WEST SUSSEX COUNTY COUNCIL CONSULTATION

TO:	Arun District Council FAO: Mr S Davis
FROM:	Highways, WSCC
DATE:	12/11/2018
LOCATION:	Beech Cottage, 99A, North Bersted Street, Bognor Regis
SUBJECT:	BE/88/18/DOC Application for approval of details reserved by condition under previously approved planning permission BE/133/16/PL relating to condition No. 3 (surface water drainage), 4 (flows to watercourses), 5 (watercourse arrangements) & 6 (Site set up).
DATE OF SITE VISIT:	n/a
RECOMMENDATION:	☒ Advice ☐ Objection ☒ Modification ☐ No Objection ☐ More Information ☐ Refusal
S106 CONTRIBUTION TOTAL:	n/a

Drawing 2 - Block Plan

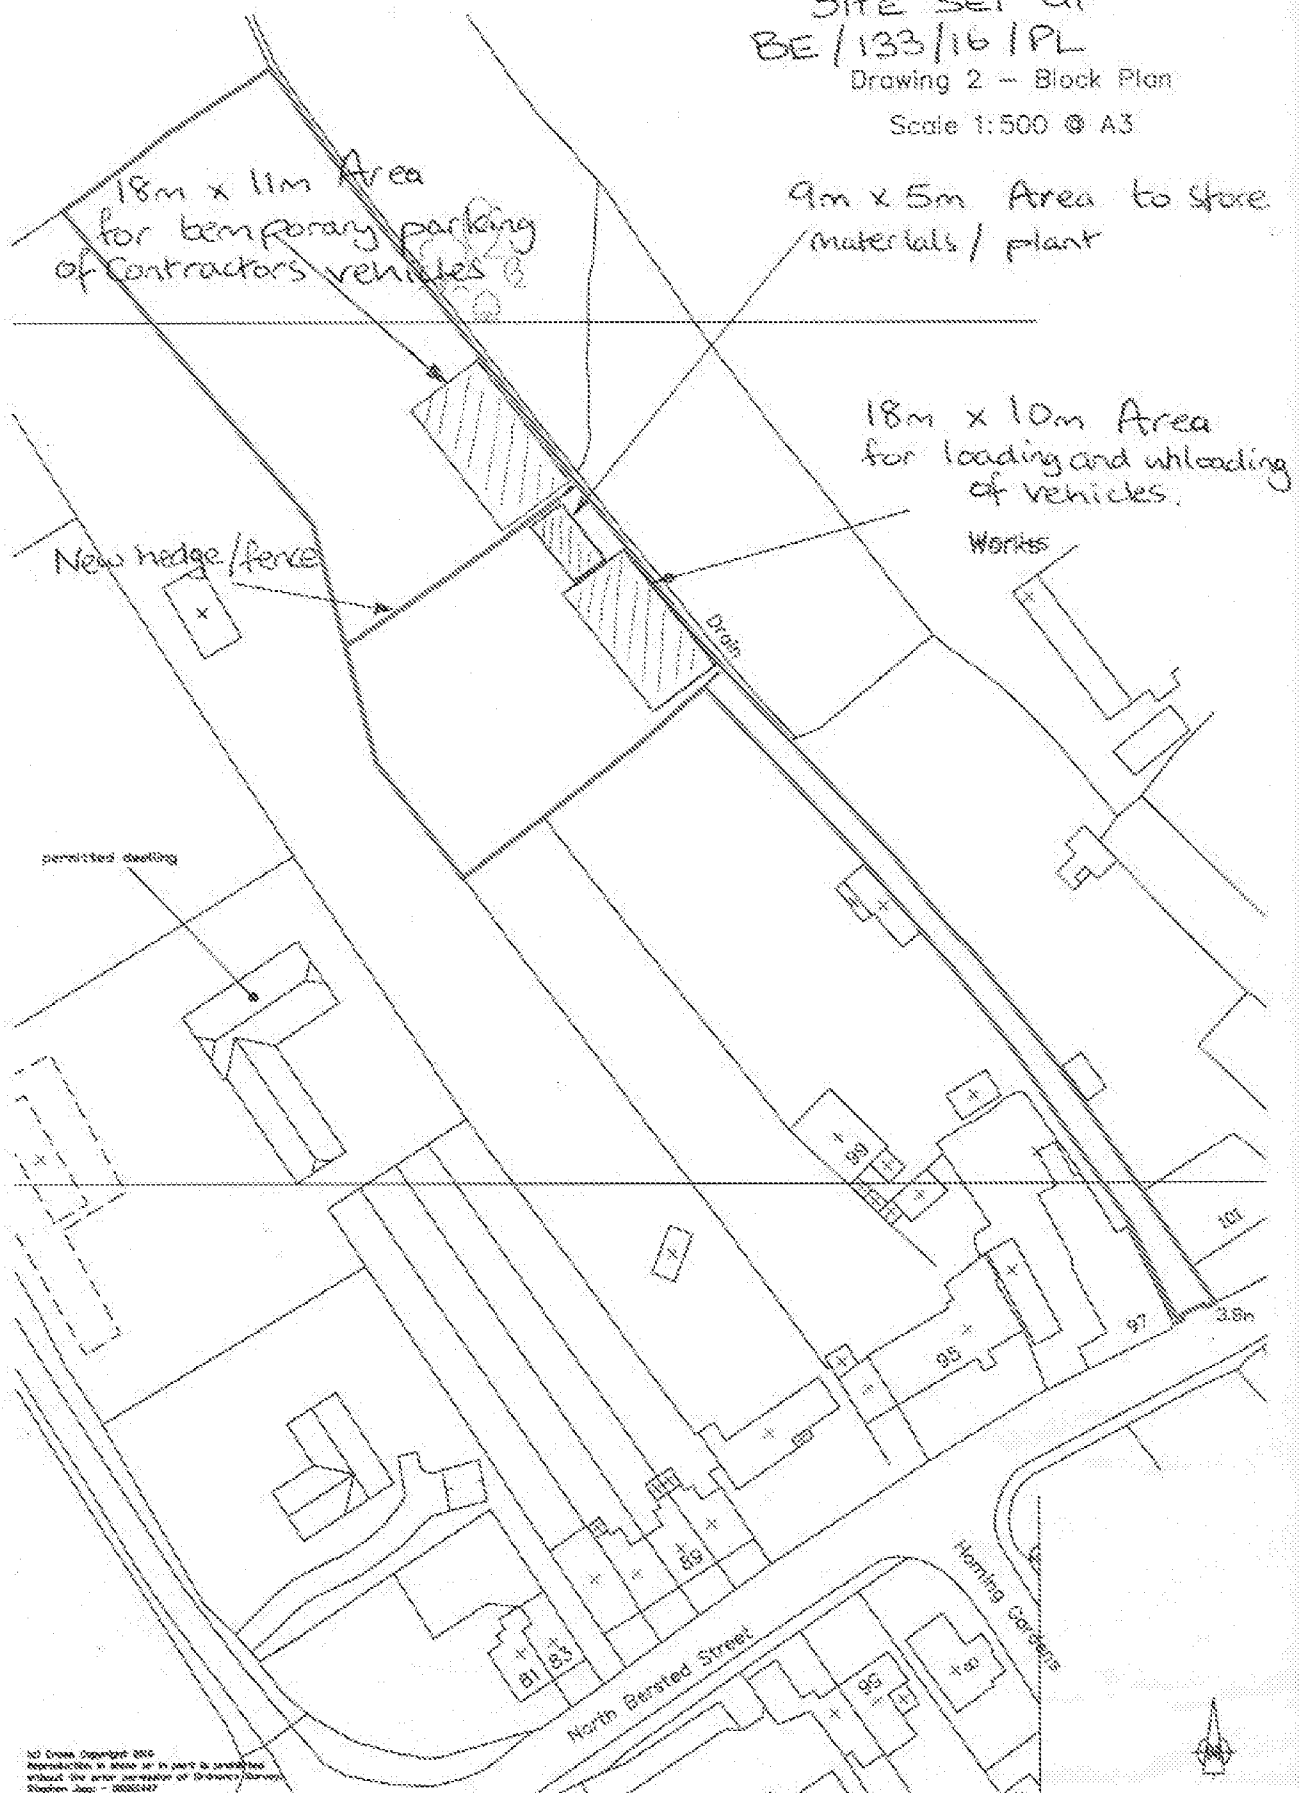
The applicant has provided a site set up plan to fulfil the requirements of condition 6. All materials/plant storage and contractor parking requirements will take place within the confines of the site. Given the opportunity for turning has not been demonstrated the Local Highways Authority would request an annotation on the submitted plan to ensure any reversing vehicle movements out of the site access onto North Bersted Street are undertaken with the aid of a banksman. Subject to this modification no highways concerns would be raised to the plans and details submitted pertaining to this condition.
